PLANNING APPLICATION: THE OLD BARN, ARUNDEL ROAD, FONTWELL, BN18 0SX

Thank you for consulting us on this planning application for The Old Barn, Arundel Road, Fontwell. This application is for the siting of a second mobile home and storage of two caravan units for Travelling Show Persons.

Mr. J. Horton			
The Old Barn, Arundel Road, Fontwell. BN18 0SX			Richard Stubbs MRTPI
Mobile Home (2nd) and 2 Caravans			TEL: 01243 825944
1:2500 1:500 November 2012			06/12 1 of 1

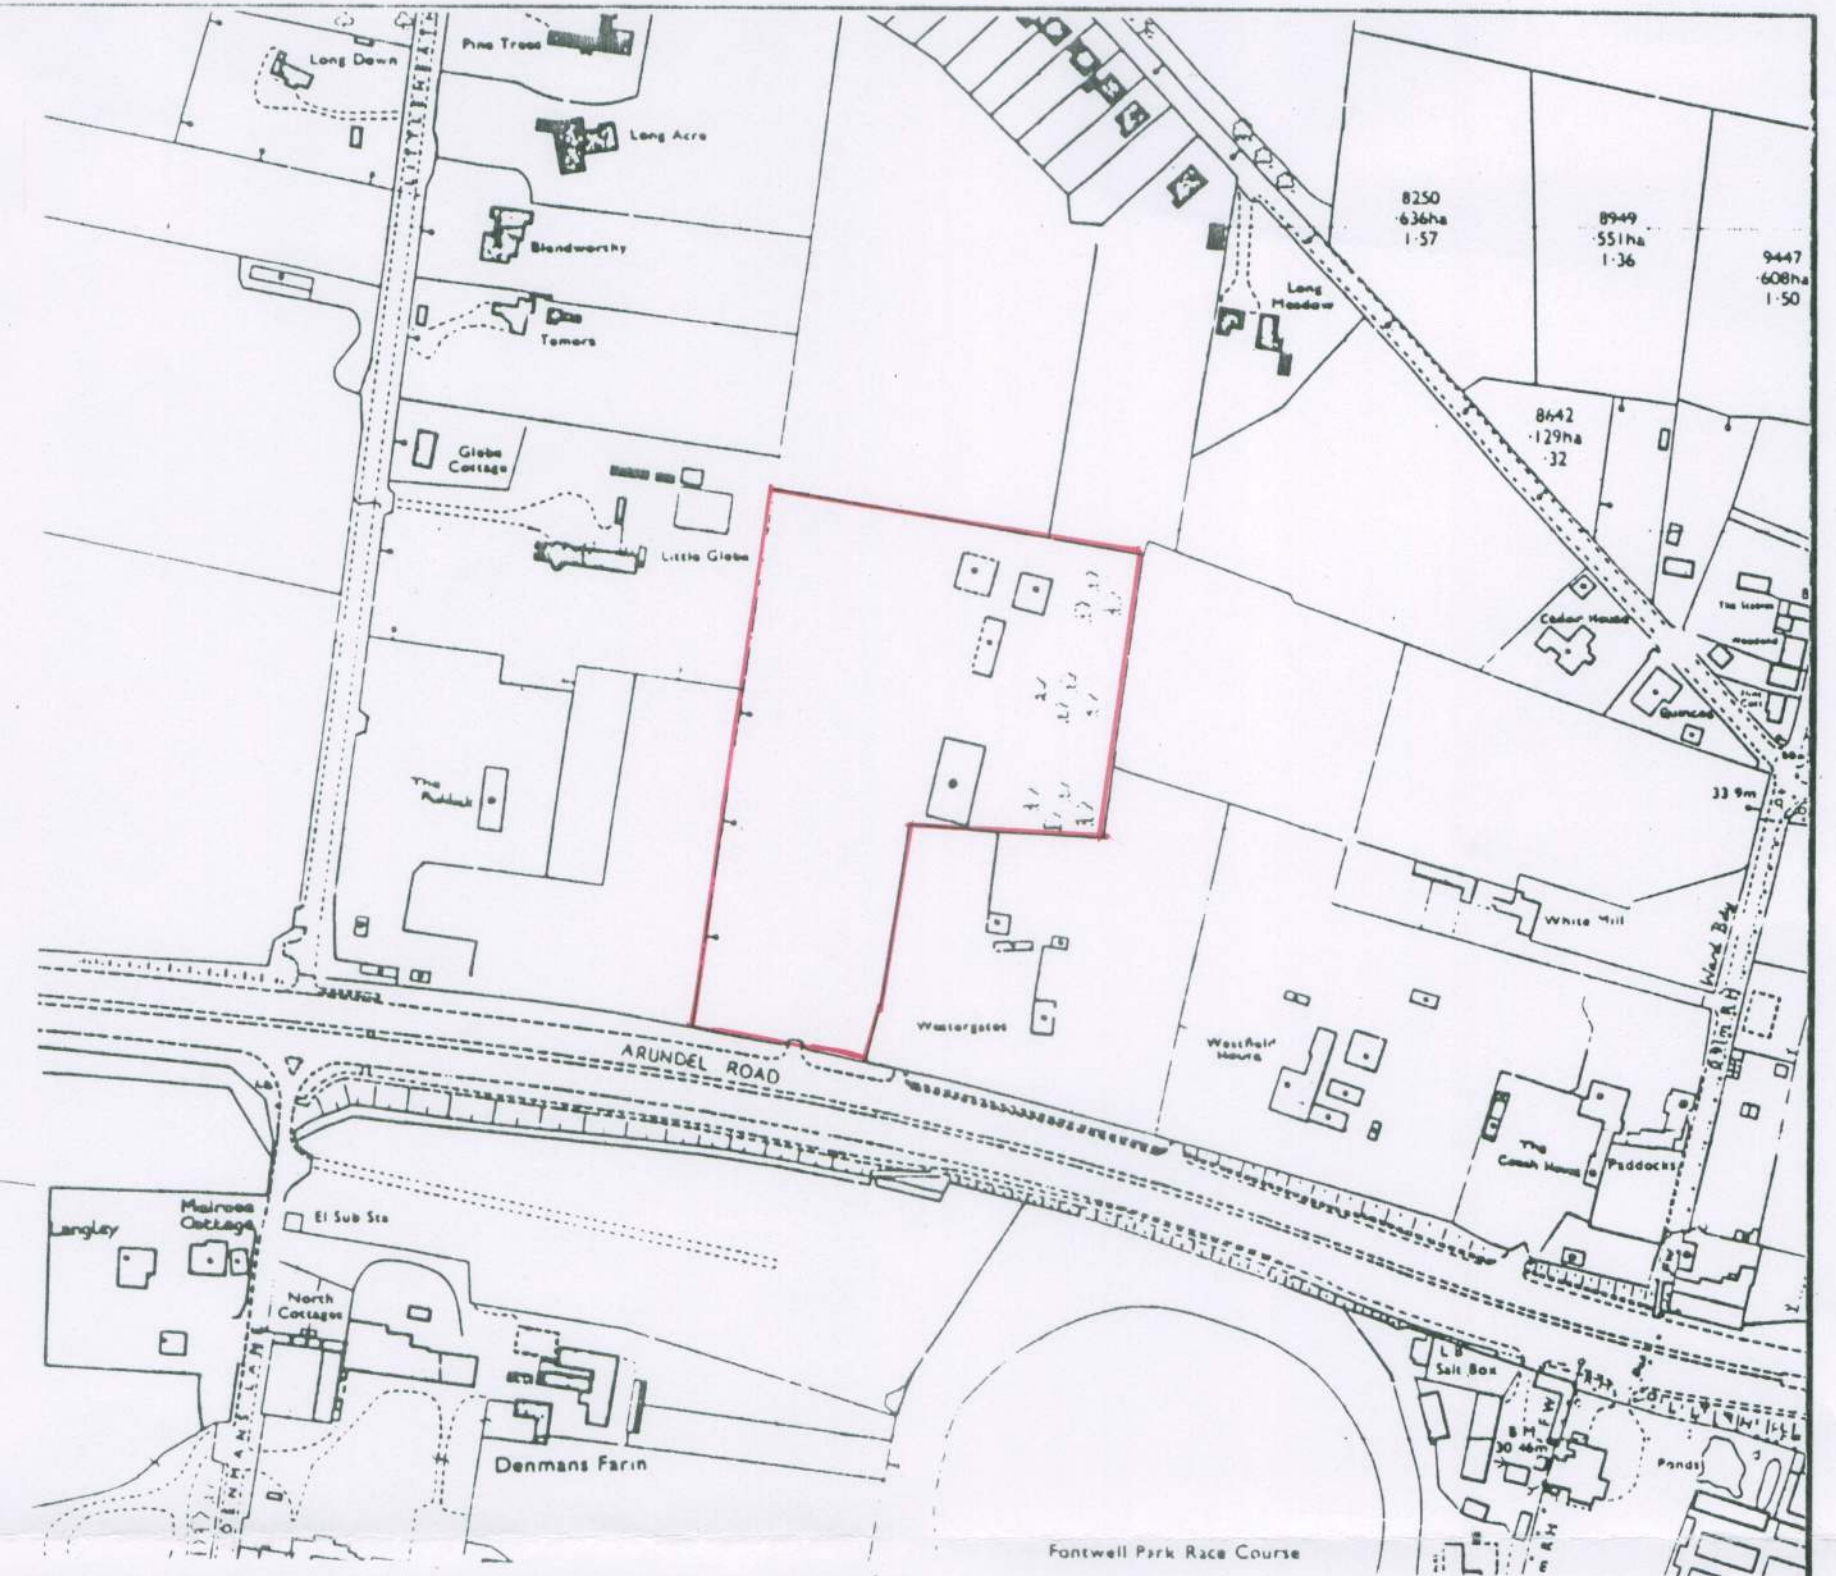
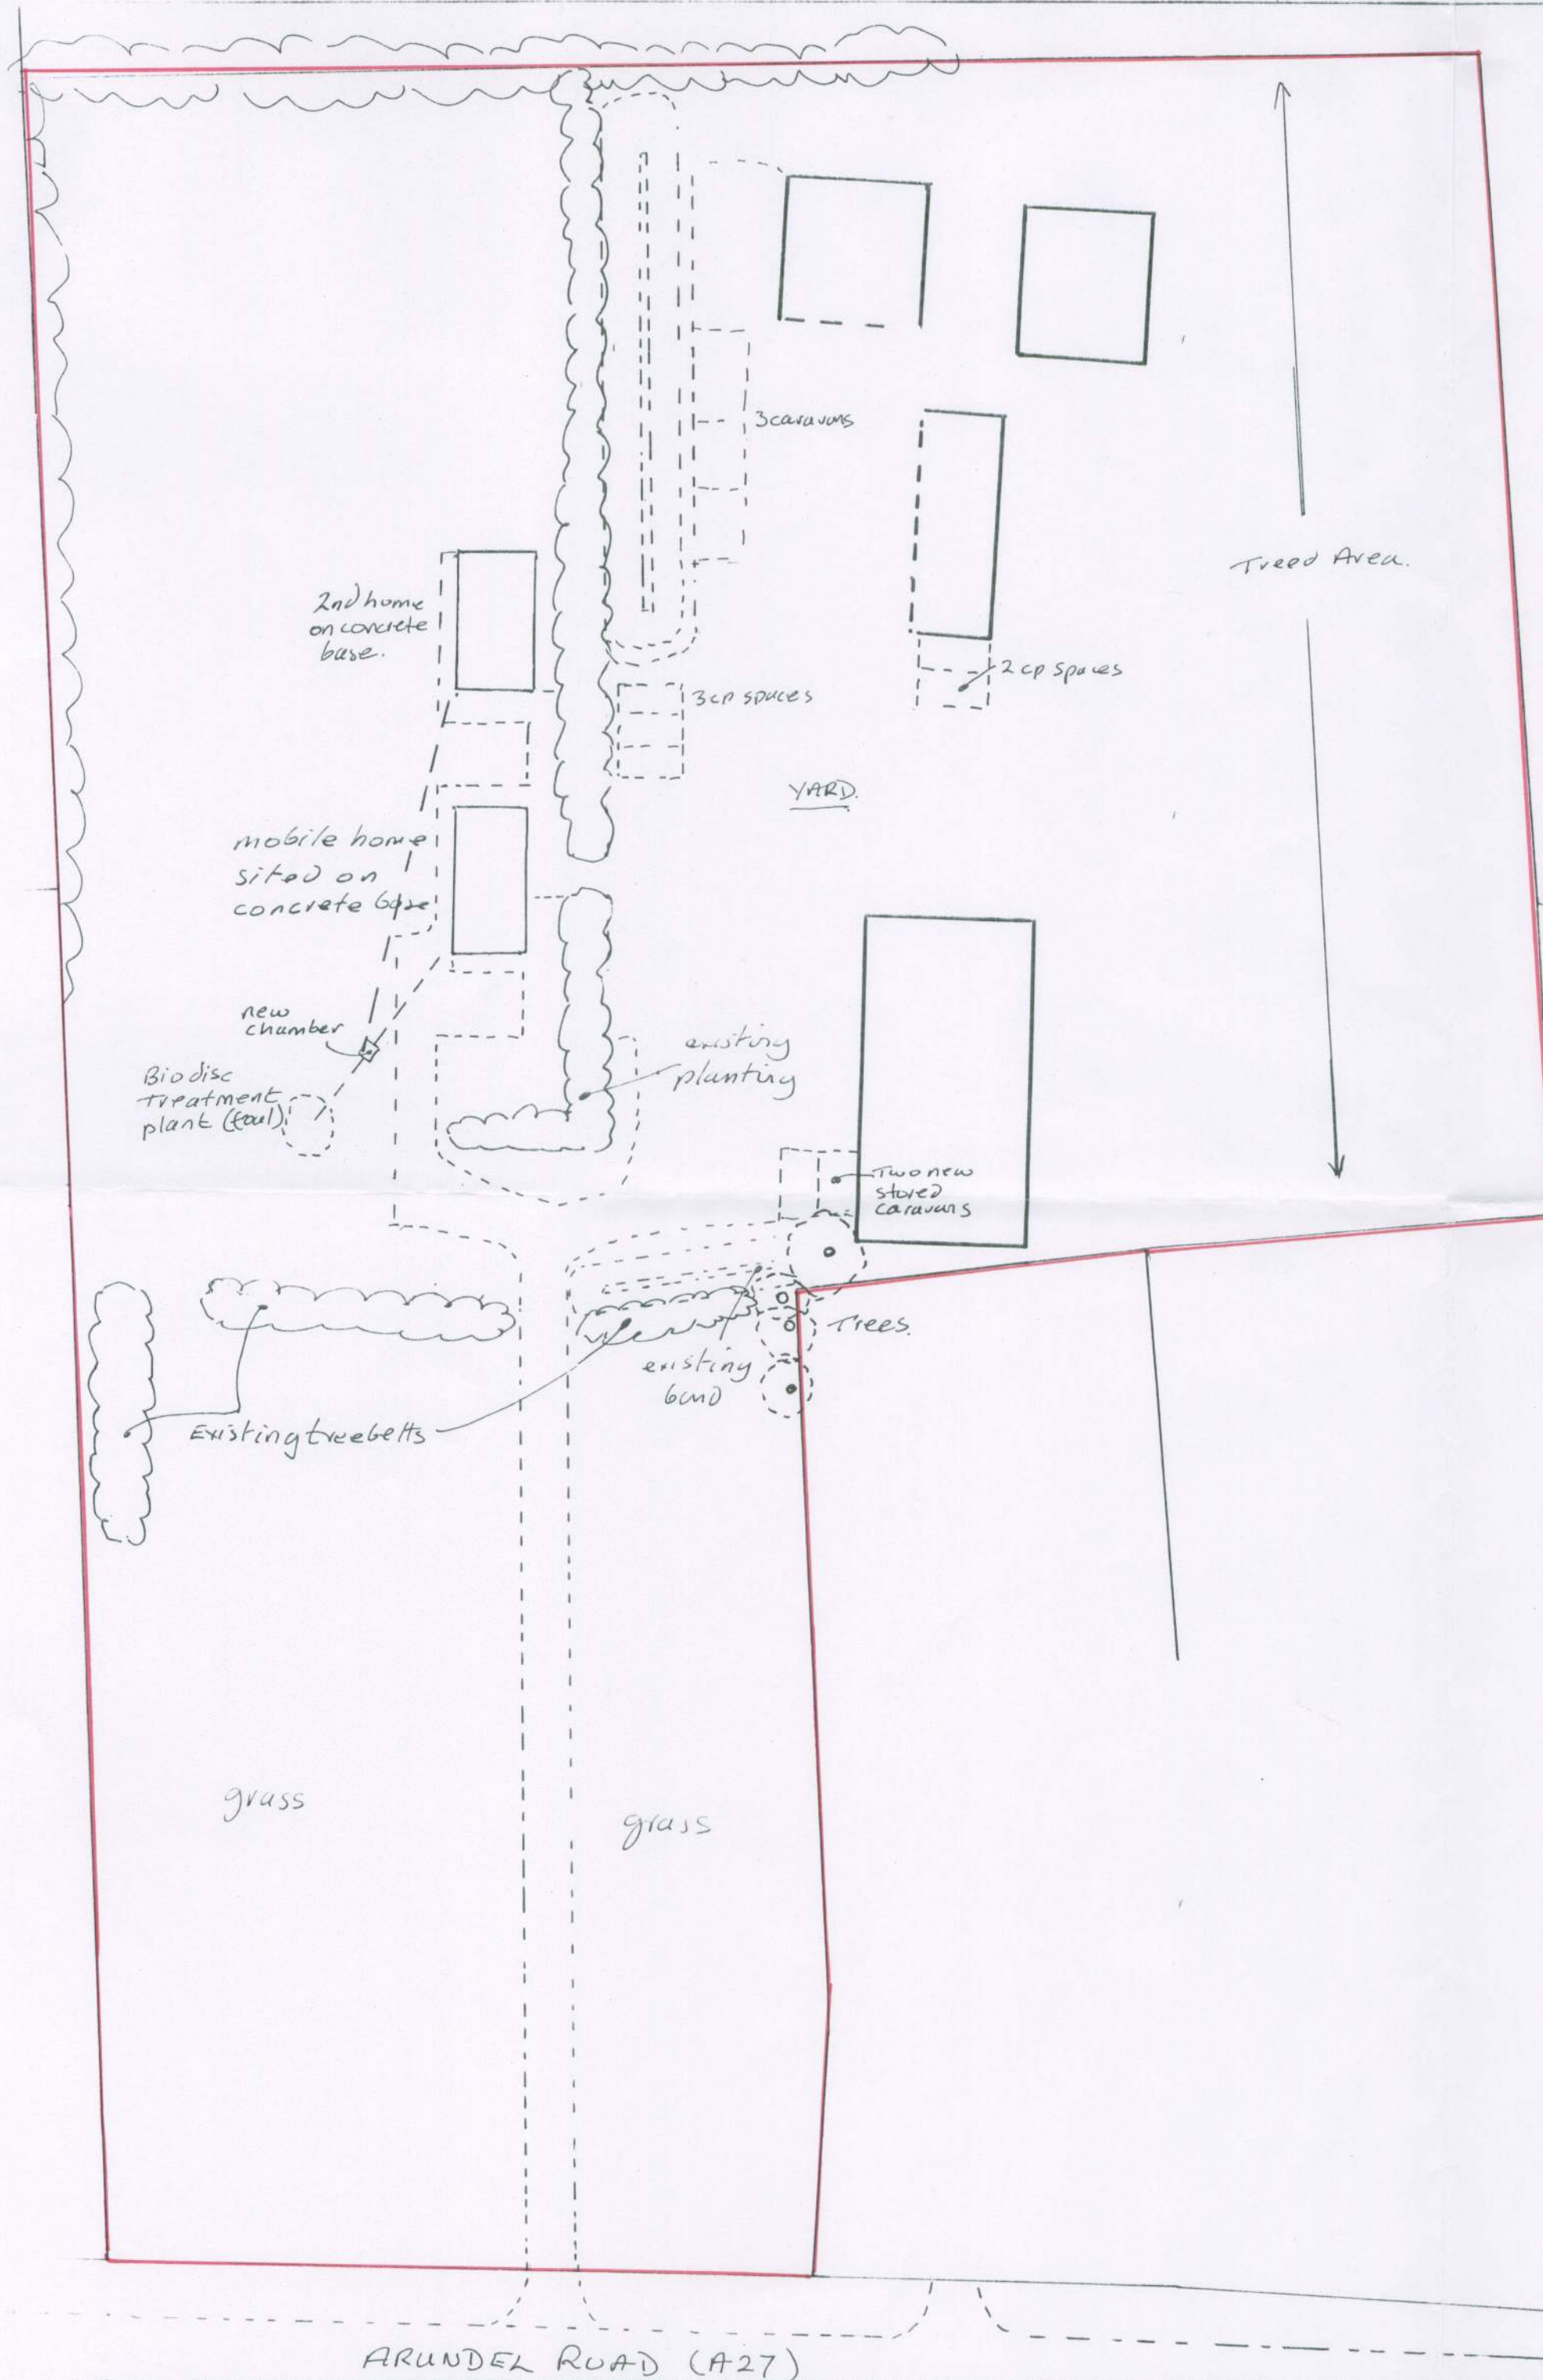
I would be grateful if you could ask the applicant to provide us with a layout plan of the proposed access arrangement onto the A27. There must be a minimum of 14 metres distance between the edge of the A27 carriageway and the site gates. The gates must open inwards into the site. The access radii must conform to the requirements set out in TD41 of the Design Manual for Roads and Bridges.
